DECISION DELEGATED TO HEAD OF PLANNING

Application No: H09-1005-24 **Applicant:** Ms C Holmes

Proposal: Demolition of existing agricultural building benefitting from Class Q approval (Ref: H09-0420-24) and erection of chalet bungalow and attached associated garage block

Location: 98 Dog Drove North Holbeach Drove Spalding

Site Plan
Scale: 1:200
metres

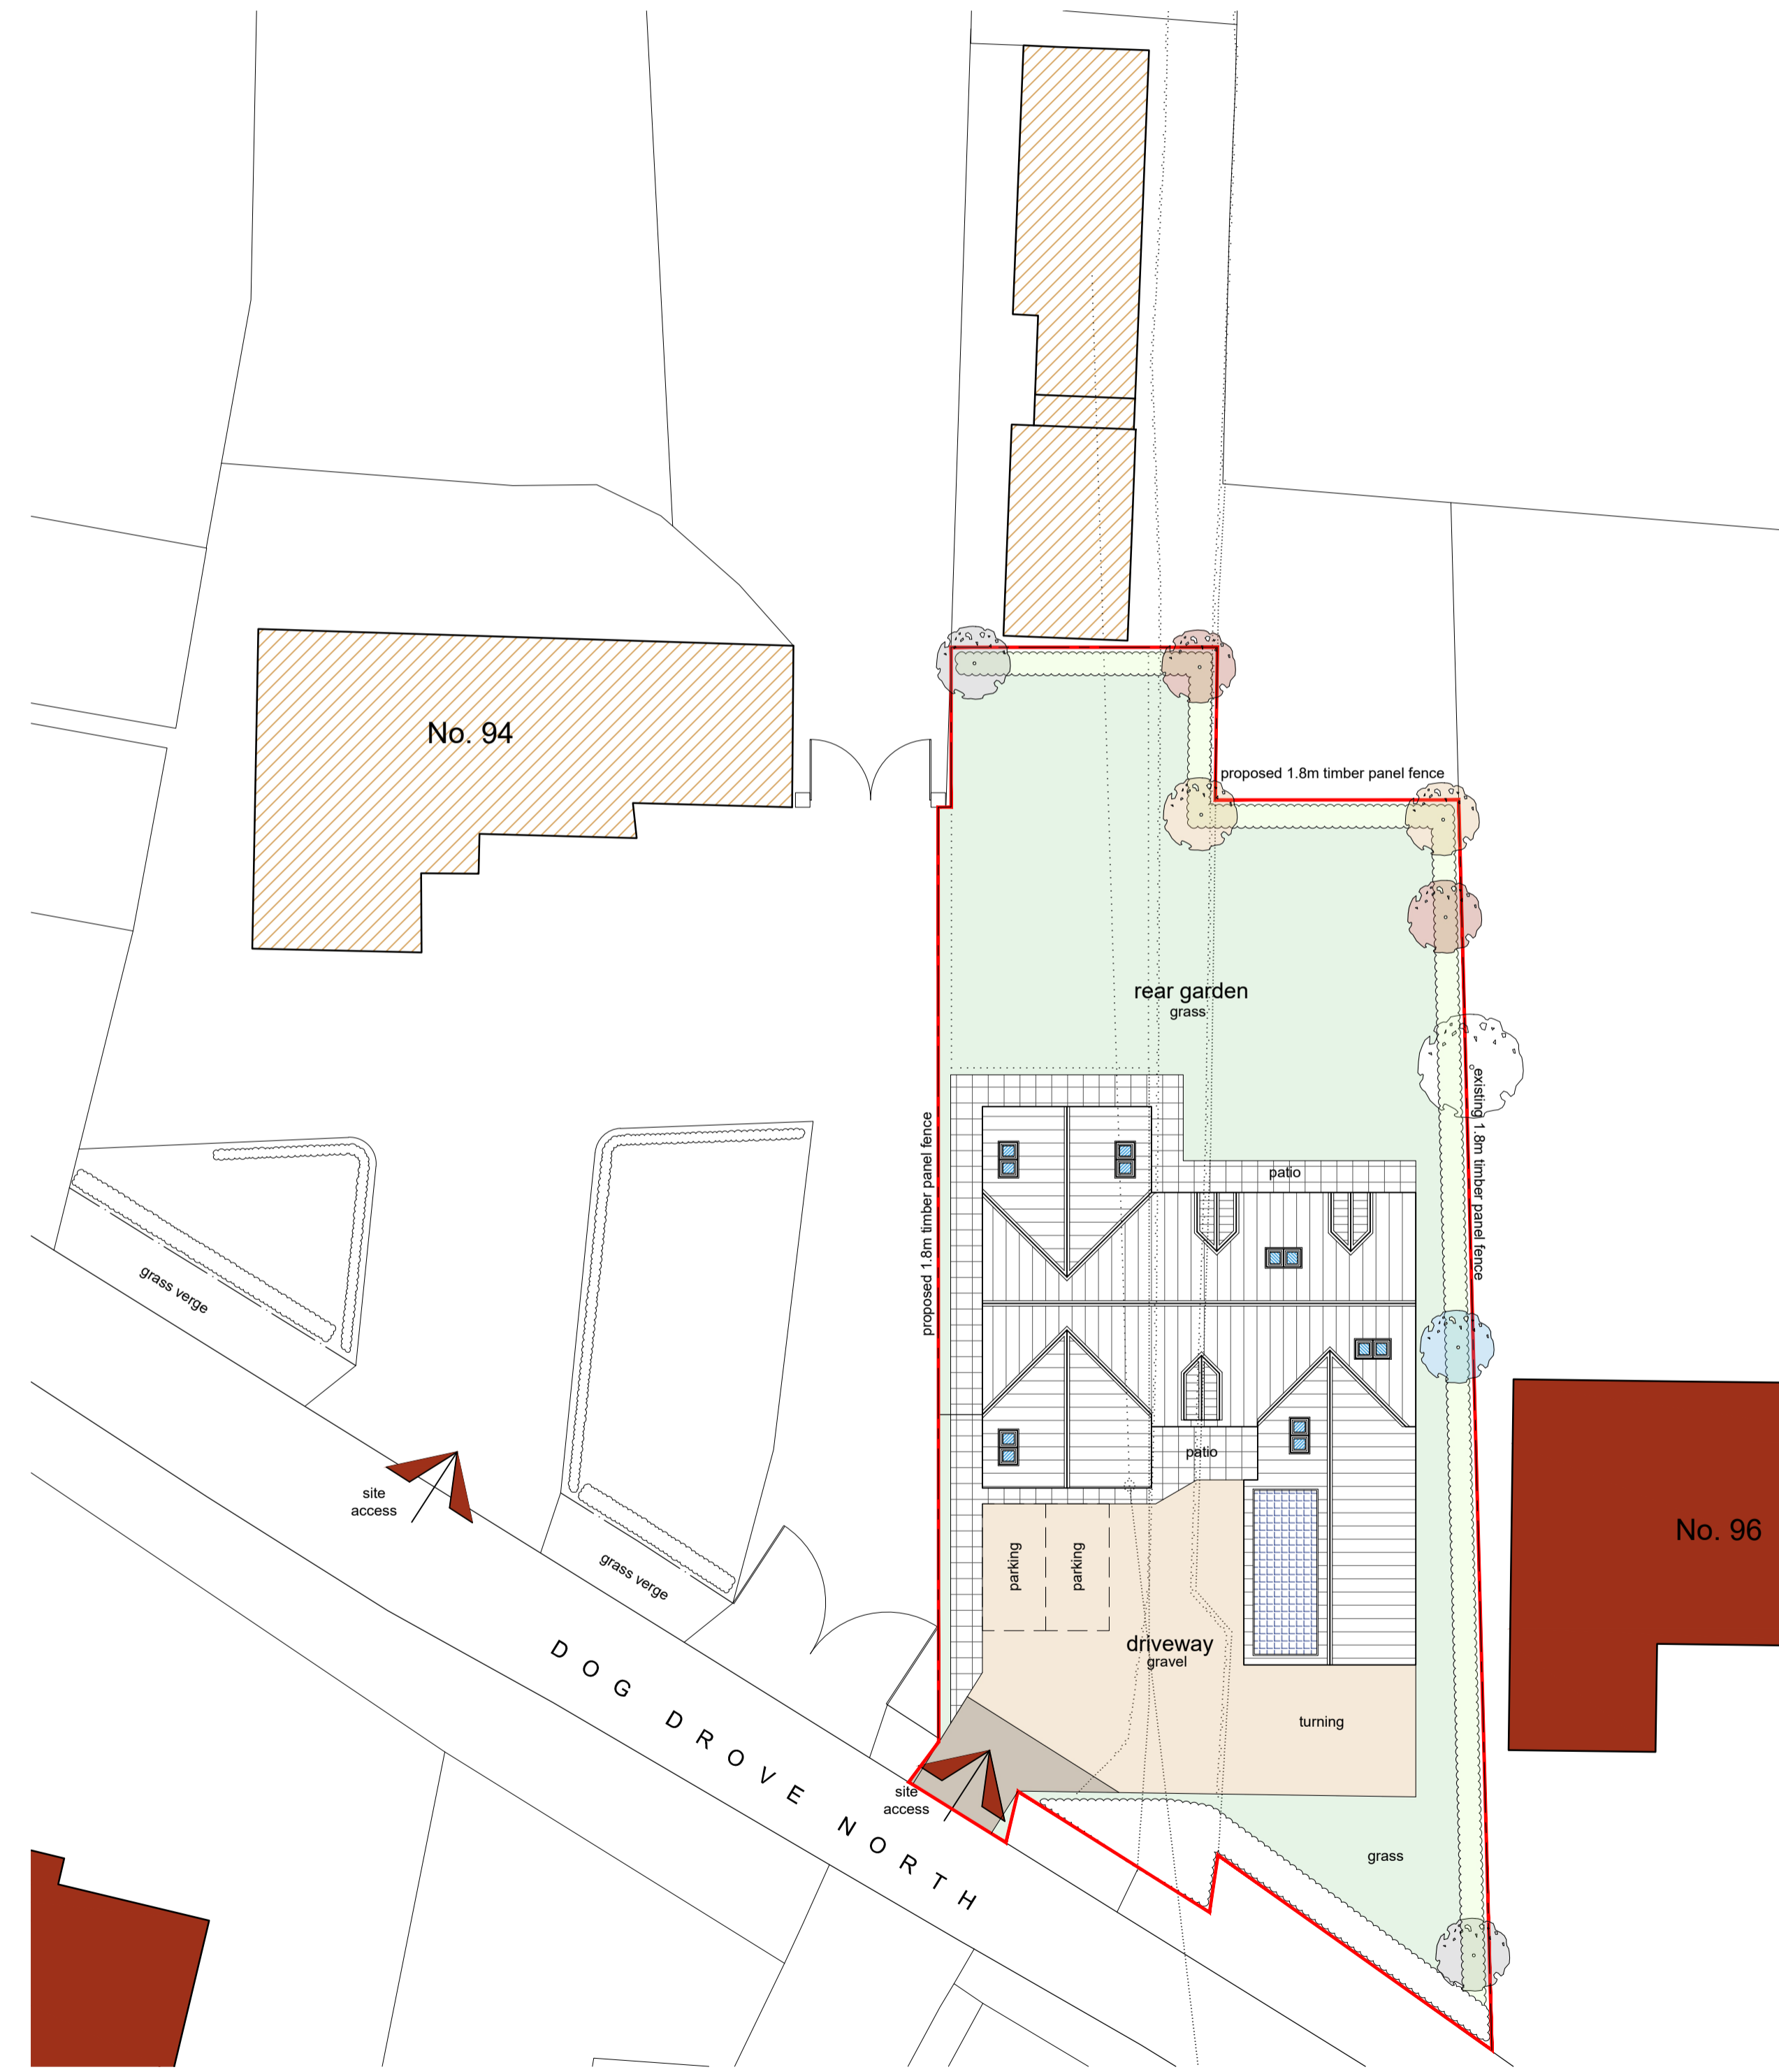
Requests additional information: "In accordance with the approved plans for 0420-24 the access is to be upgraded to Lincolnshire County Council Specification and a note should be added to the proposed site plan."

The proposal would result in the creation of a new site access, rather than the utilisation of an

existing access as proposed under H09-0420-24, without blocking up any of the existing accesses to the site. It could be argued that this creates a somewhat confusing layout, with three accesses all opening onto the road in a relatively short space of time. The Highway Authority have requested additional information, in the form of confirmation that the access is upgraded to LCC standards. This information has not been sought due to the principle issues identified above; however, a condition to this effect could be imposed if required.

Front Elevation (E)  
Scale: 1:100

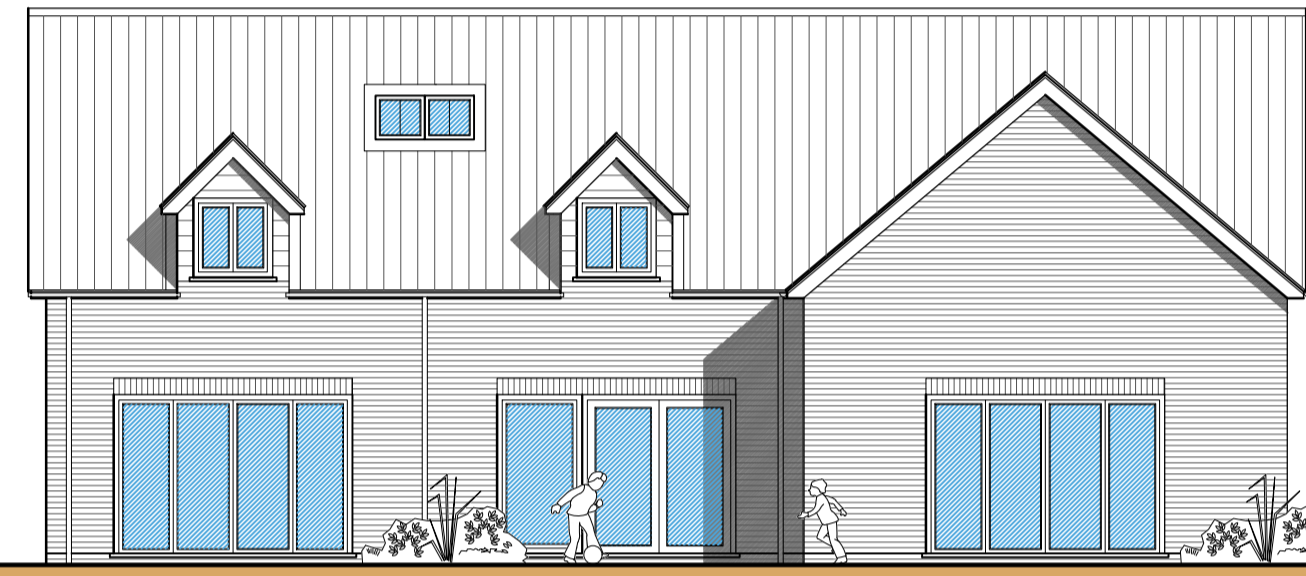
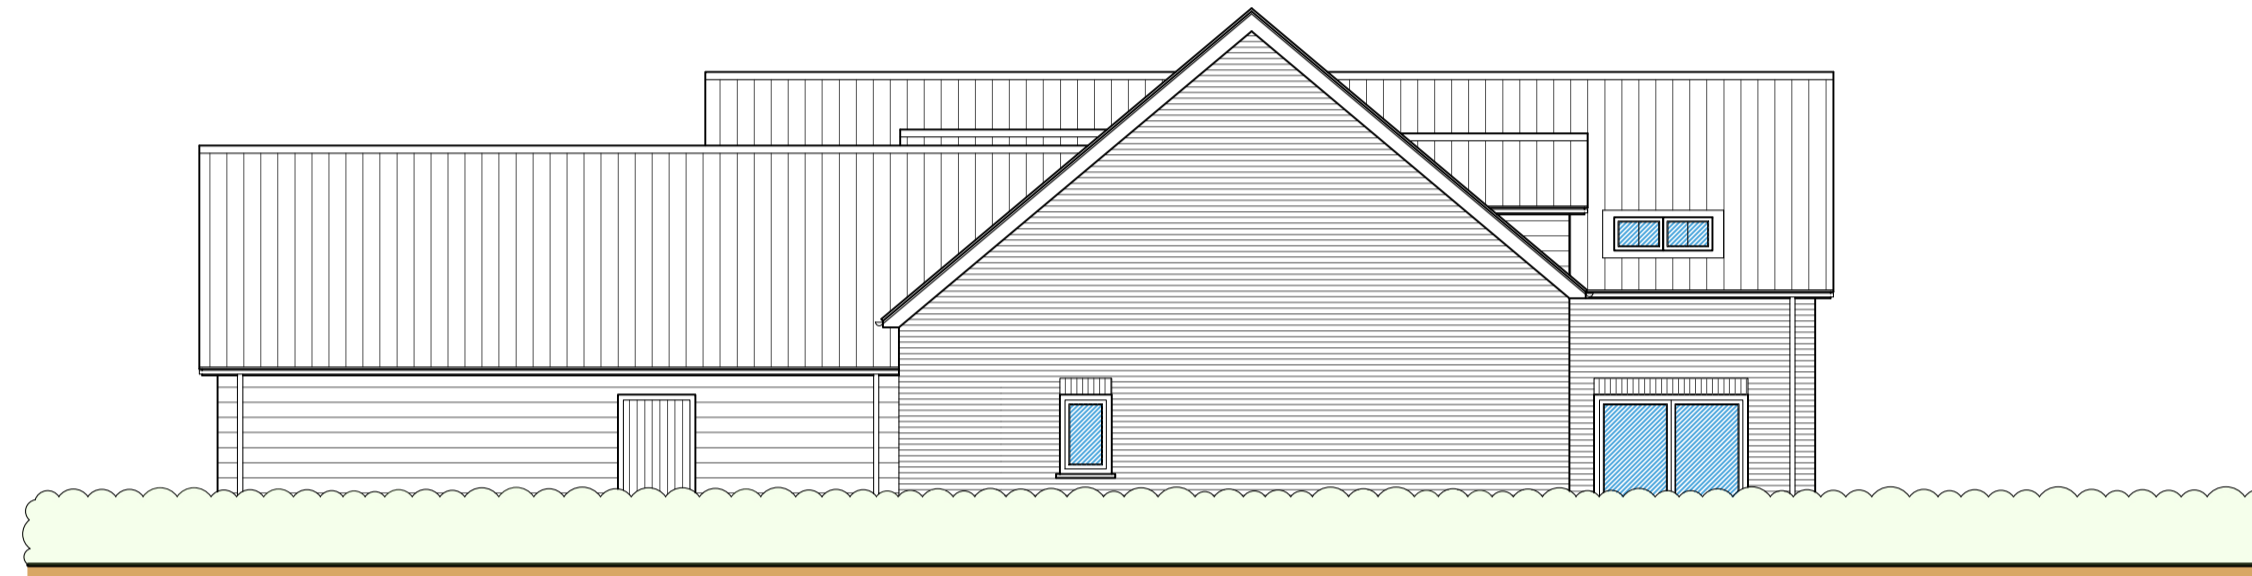
Turning now to an assessment of the development proposed here, the proposed dwelling is significantly larger than, and on an entirely different footprint to, the existing agricultural building on site. The significant increase in scale would therefore exacerbate any potential character impacts emerging from the development, when compared to those emerging from H09-0420-24. The resultant dwelling would have a footprint area approximately 50sqm greater than its nearest counterpart in terms of scale (which would be 96 Dog Drove North, measuring at approximately 190sqm footprint compared to the approximate 240sqm of the proposed dwelling here). The proposal would therefore represent a relatively significant departure from the established built form of the area.

The effect of this significant scale is increased by the relatively small plot size, resulting in a cramped form of development, at odds with the more spacious character of the area. The claustrophobic effect of the development would be worsened by its impact upon 96 and 98 Dog Drove North, which would both see their plot size decreased due to the development; therefore, making both of these plots appear more cramped as a result. To this end, the proposal would conflict with Paragraph 53 and 56 of the NDG.

The impacts of this proposal are further exacerbated by its positioning. In repositioning the scheme to approximately 15m from the roadside, the development becomes more imposing. This then exacerbates the visual effect of the relatively small plot and its relationship with adjacent dwellings, to create an overly prominent and unduly dominant development.

Turning to the materials of construction, no clear indication of the brickwork or timber cladding has been provided at this stage. With the exception of the existing agricultural building on site, timber is not a common material in the area. To this end, the agricultural building is somewhat of an outlier, although this can be excused somewhat by its practical nature. Timber cladding is not paired with brickwork at any point in the immediate area. To this end, the effect of the two materials together would be to create an incongruous development, which fails to respect existing precedent. As such, the proposal is considered to be contrary to Paragraphs 53 and 57 of the NDG. The effect of this incongruous design is exacerbated by its prominent positioning in the street scene.
